Objection to Planning Application AW/197/20/PL

Planning Application AW/197/20/PL The former Ship Inn Variation of Conditions applied to previous Planning decision AW/211/14/PL

Client
Surplus Property Investments
Project
The Former Ship Inn, Aldwick Street, Bognor Regis. PO21 3AP
Title
Vehicle Tracking : Cars Passing Delivery Vehicles
Scale
1:500 @ A1
Date
21.07.2020
Drawn By
PAL
Checked By
PM
Project No:
B200038
Drawing No:
B 204
Revision
-

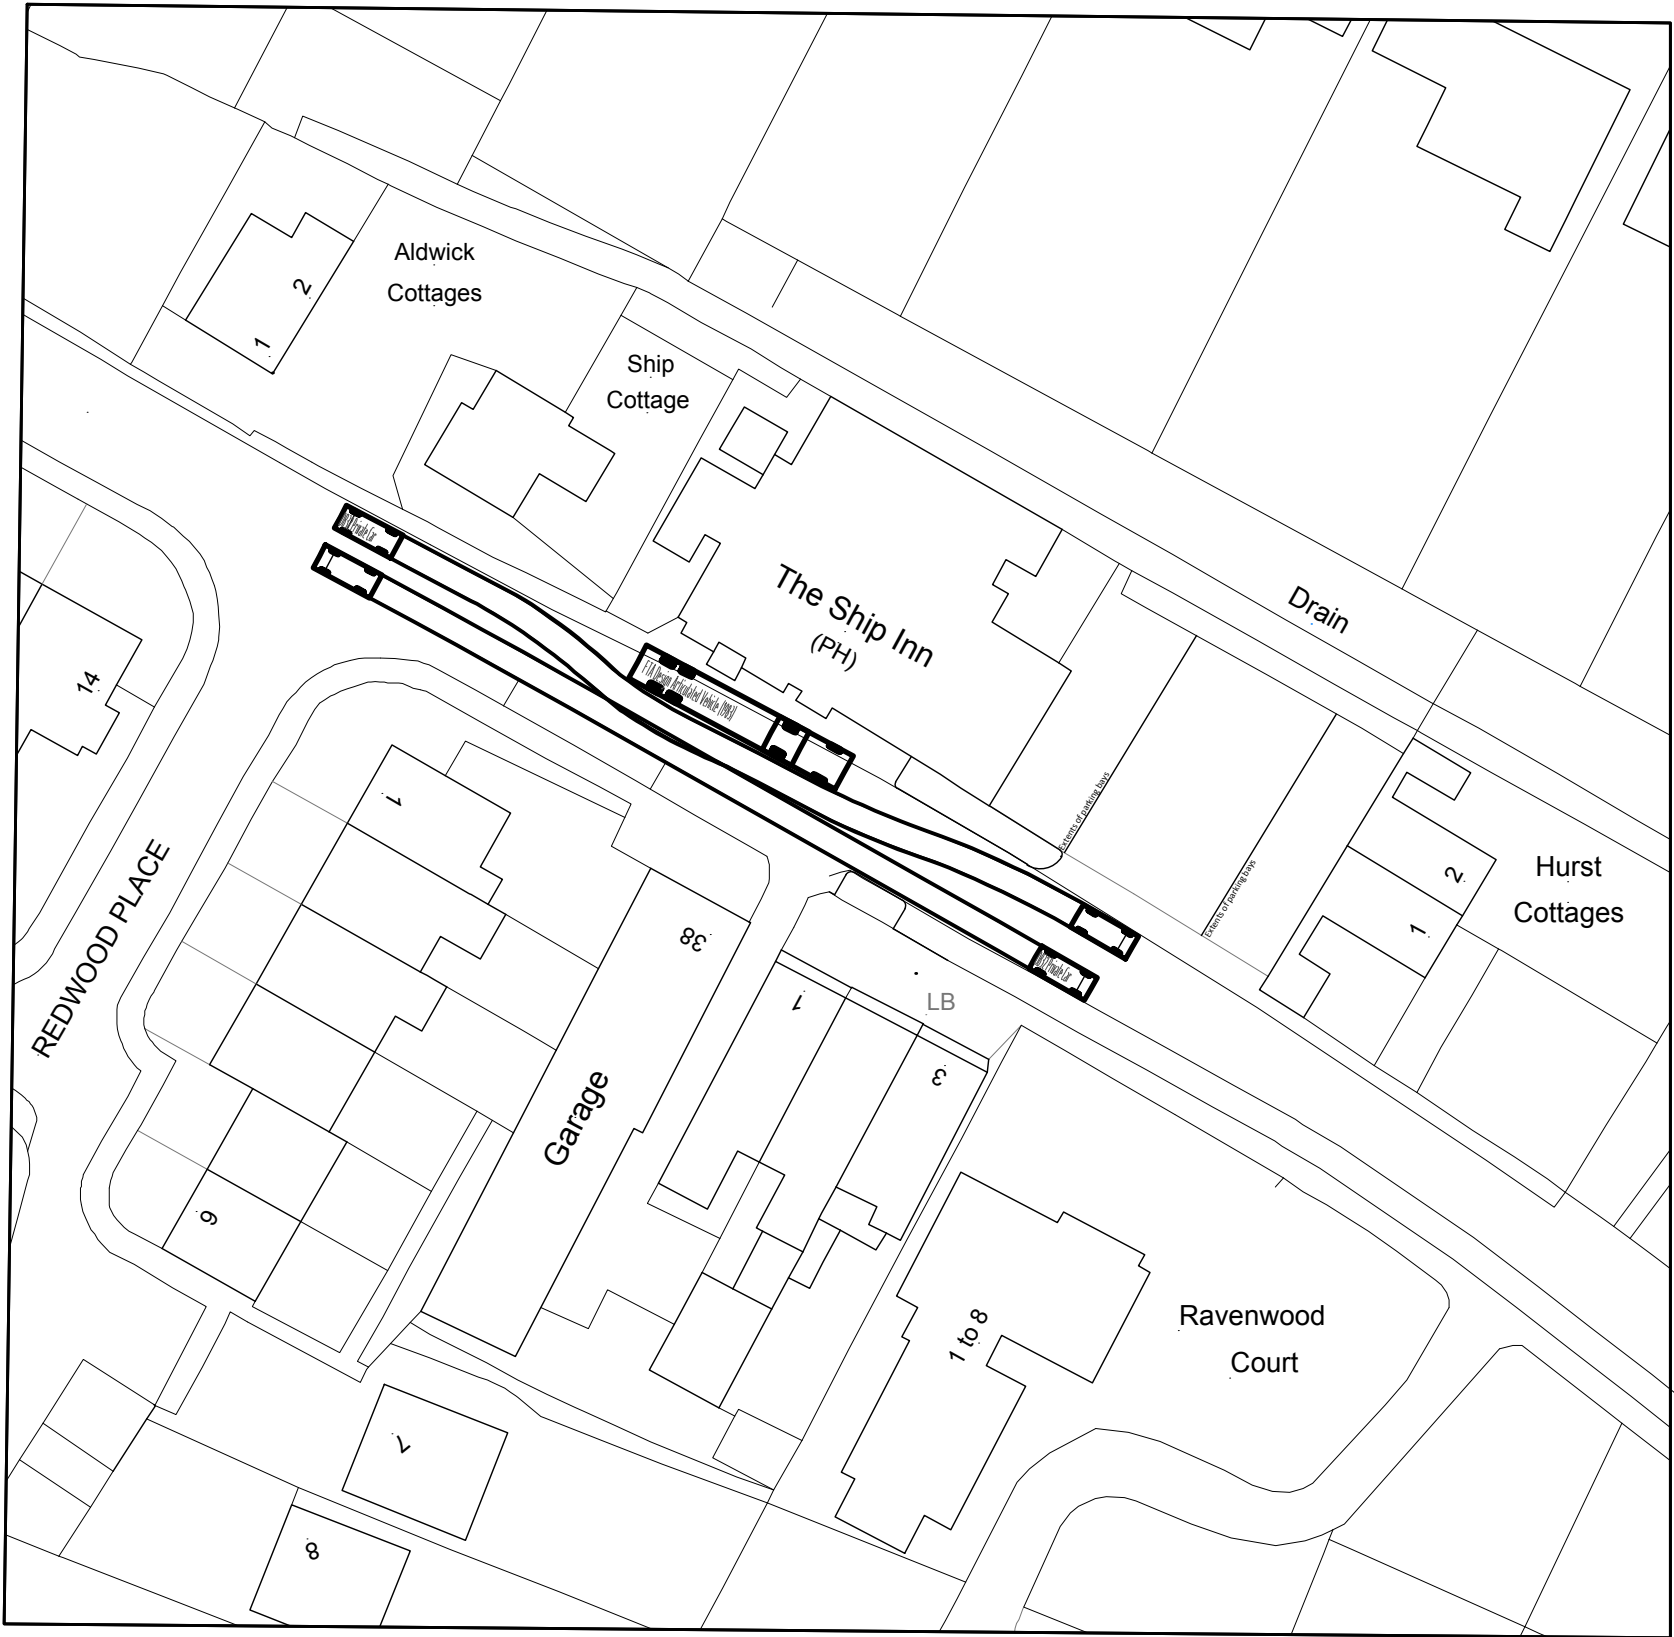
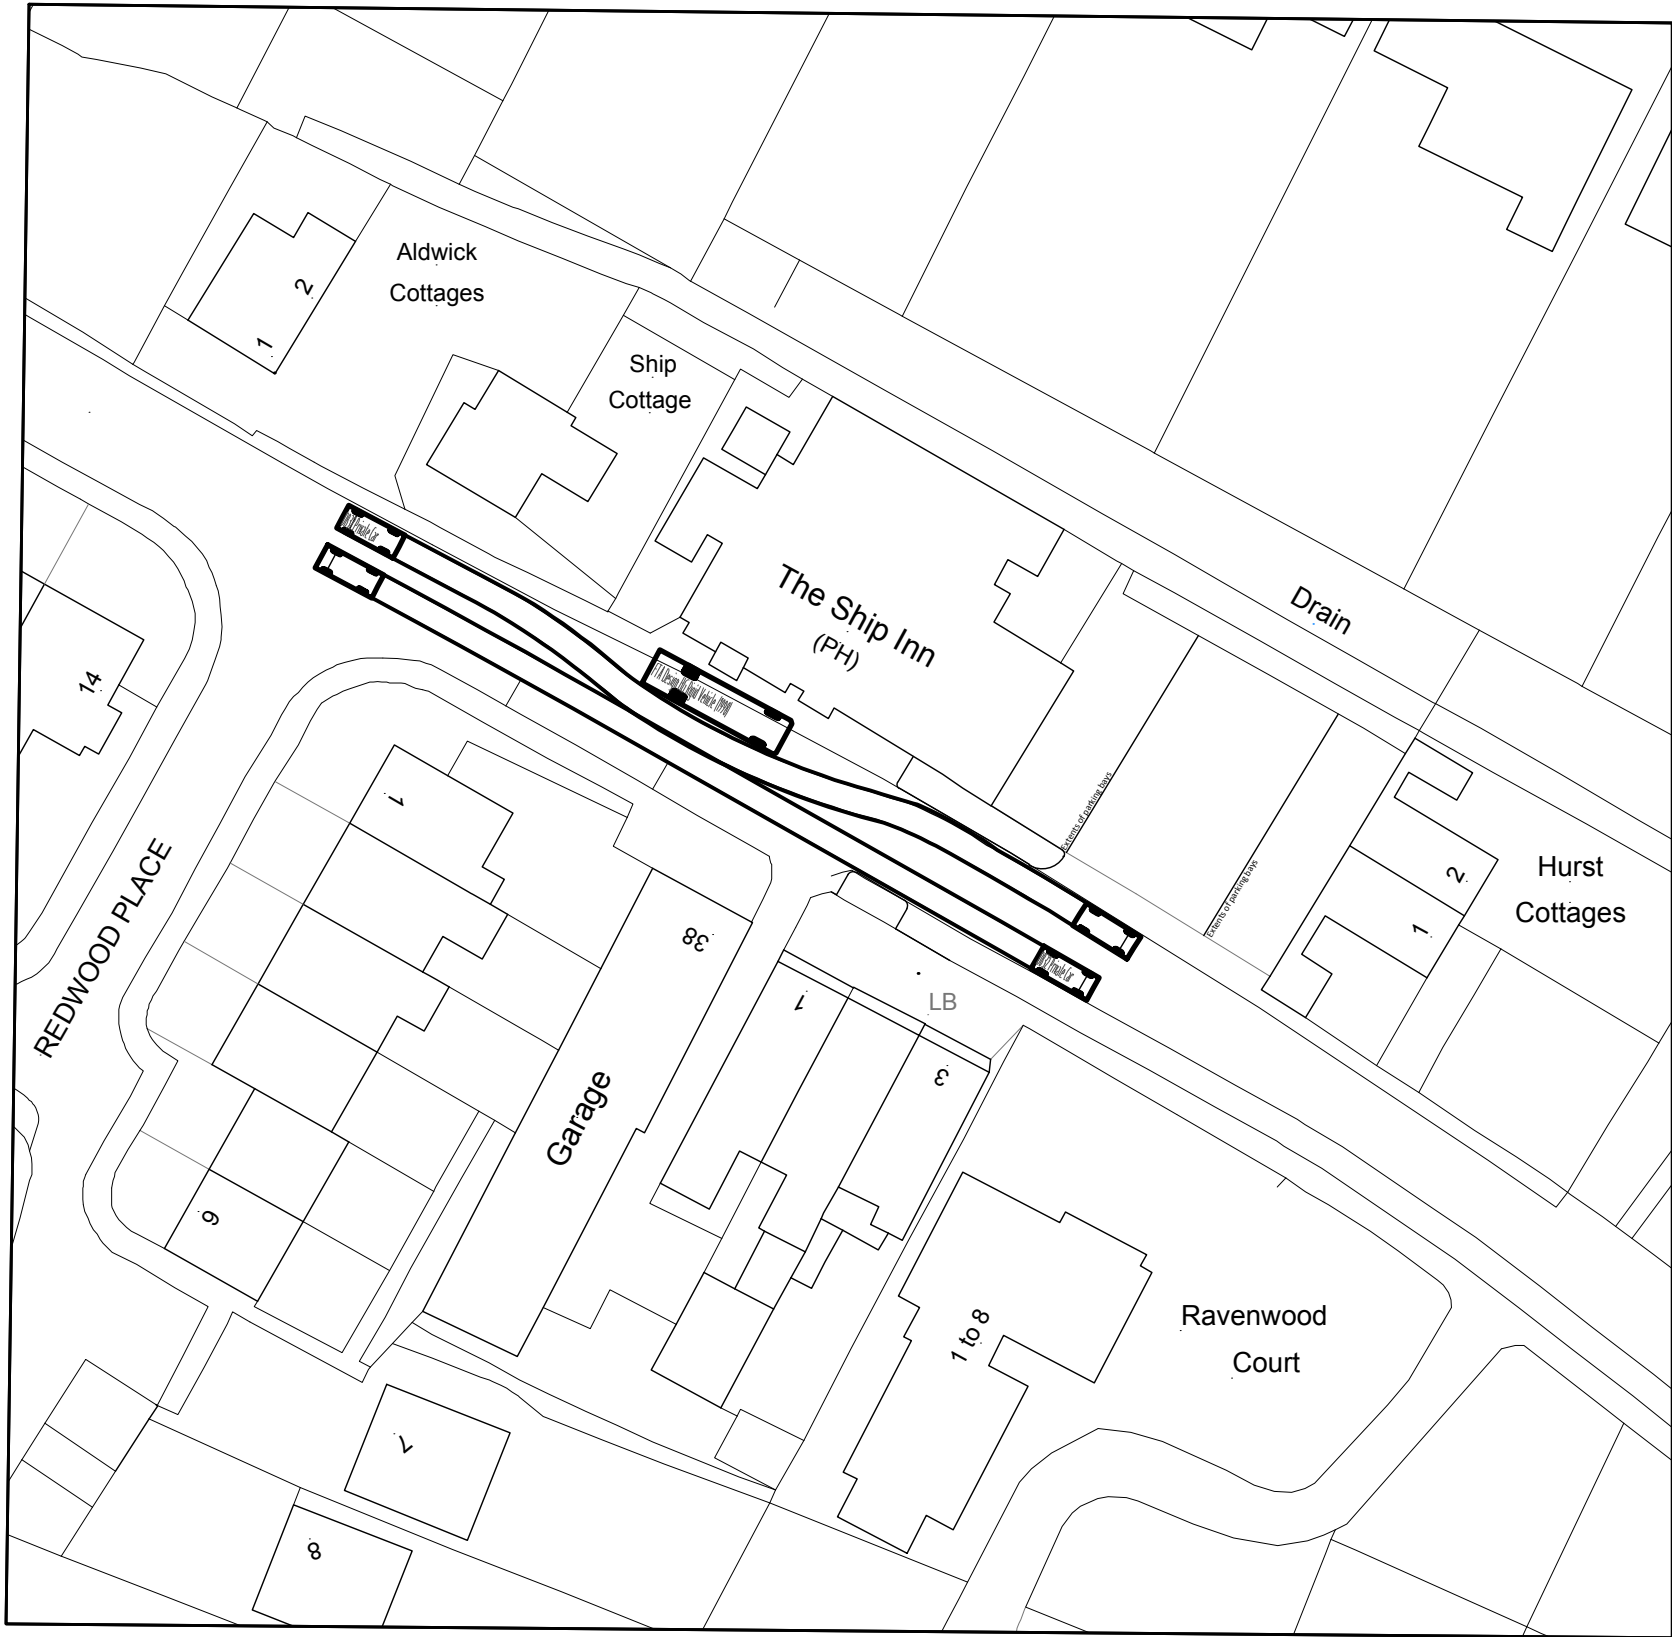
With traffic passing as close as given in the drawing B200038 B203 and B204 submitted, the unloading area will not be clear of other traffic.
